I AM WRITING TO YOU REGARDING THE PROPOSED PROPERTY ON LAND NORTH OF 13 HAZEL AVENUE WITHERNSSEA.

**SECTION THRO' A-A**  
PROPOSED - SCALE 1:50

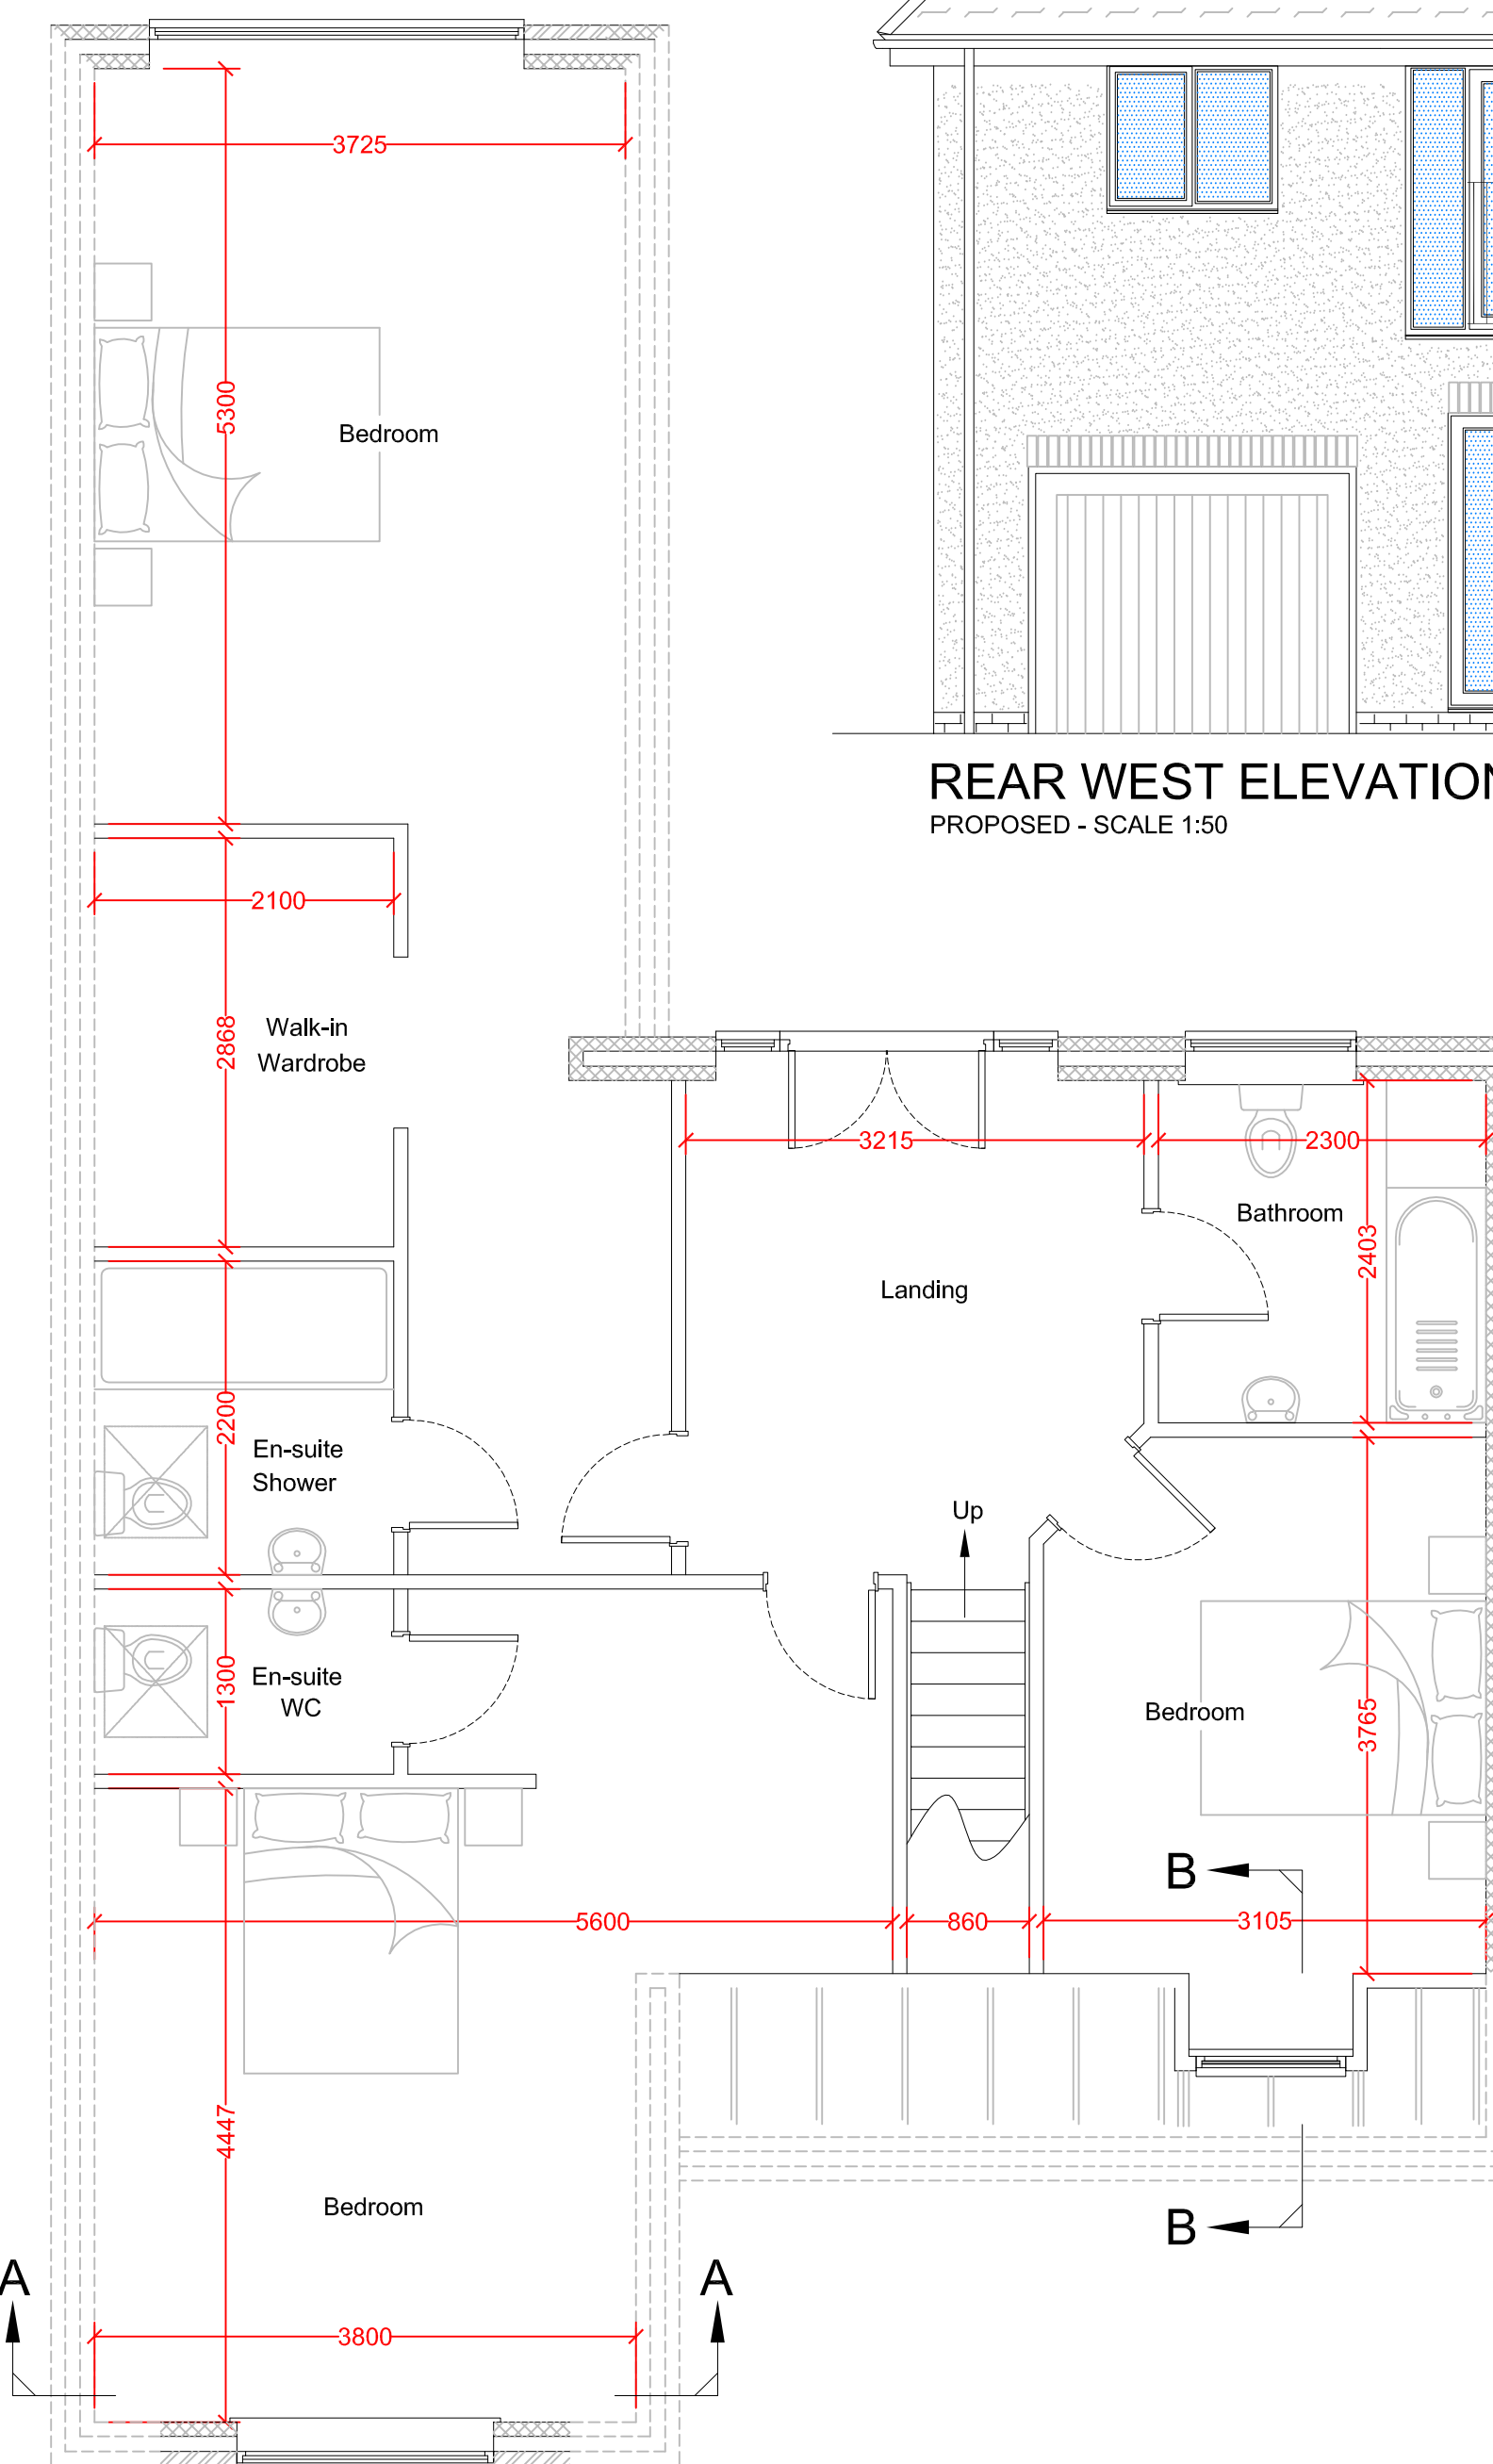
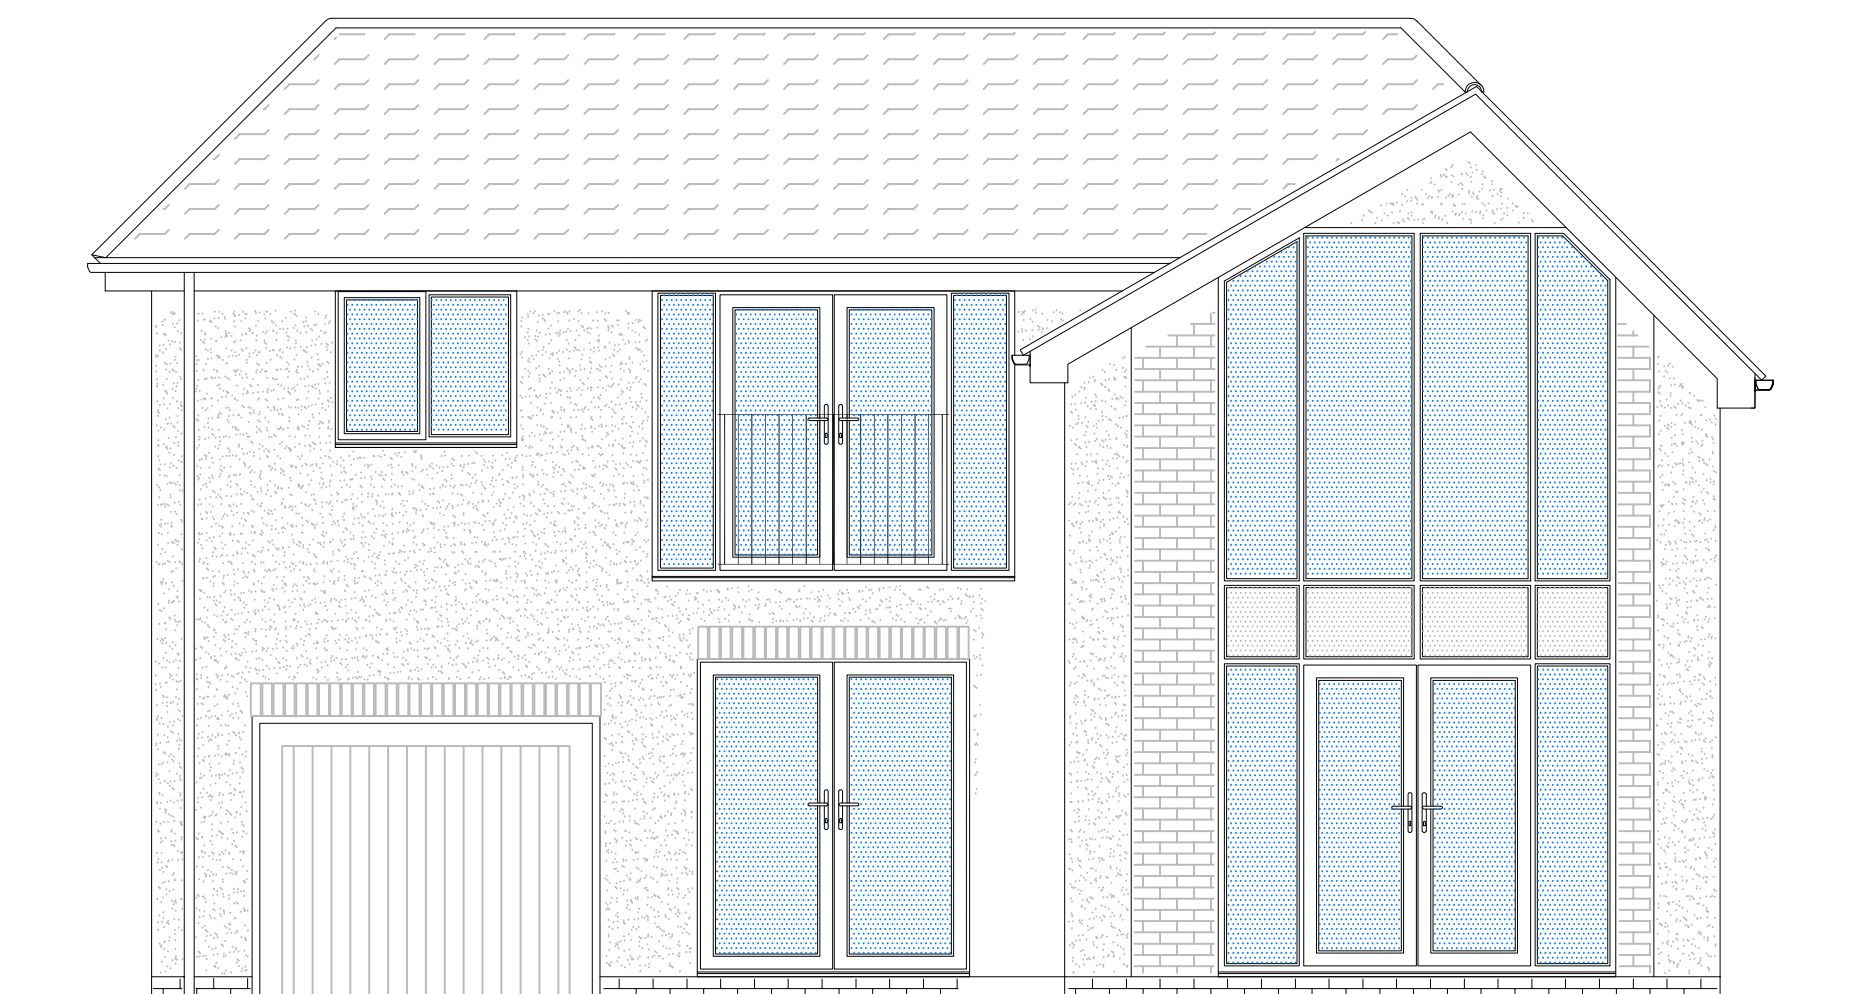
THE HEIGHT OF THE PROPOSED PROPERTY IS CERTAINLY GOING TO AFFECT MY NEIGHBOURS AT N⁰S 13 AND 15. NUMBER 13 ARE GOING TO HAVE THEIR PRIVACY COMPROMISED AS THERE ARE 2 BEDROOM WINDOWS OVERLOOKING THEIR FRONT DOOR AND GARDEN AND NUMBER 15 ARE GOING TO LOSE AN AWFUL LOT OF SUNSHINE AT THE FRONT AND BACK GARDEN. THIS HUGE 'GARDEN STORE' IS GOING TO OVER SHADOW THE BOTTOM OF THEIR GARDEN TOO.
